**Application Reference:** 6/2020/1851/COND

**Proposed development at:** 36 Salisbury Square Hatfield AL9 5AF

**Proposal:** Submission of details pursuant to condition 3 (sample of materials) 5 (parking scheme) and 6 (glazing scheme and ventilation system) on planning permission 6/2017/1902/FULL (APP/C1950/W/18/3203353)

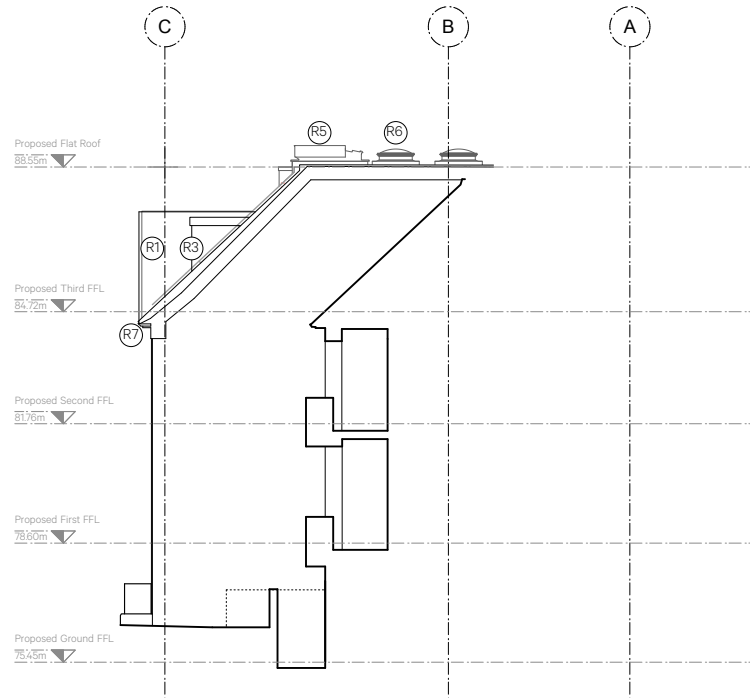
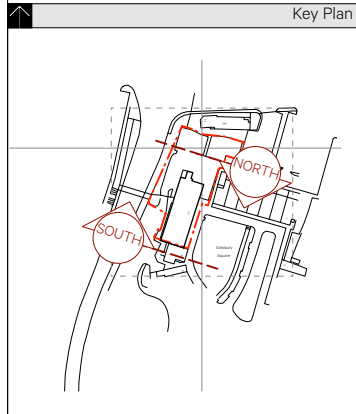
External facing materials are illustrated and annotated on submitted drawing numbers 879\_PL\_120 Revision P1, 879\_PL\_121 Revision P1 & 879\_PL\_122 Revision P1, and mistakenly includes details of proposed external facing materials for the whole building. Dormer windows approved under application 6/2017/1903/FULL are also included.

In addition, the above drawings include a smoke vent (R5) and roof/access smoke ventilation (R6) on the roof of the building which did not form part of the planning permission. The applicant would need to submit a planning application to seek approval for these proposed additions.

The external facing materials relating to the ground floor of the main building and the cycle and bin store are acceptable and approved. All other works and external facing material details included in the submitted drawings are not required by condition 3 and are not relevant to the planning permission.
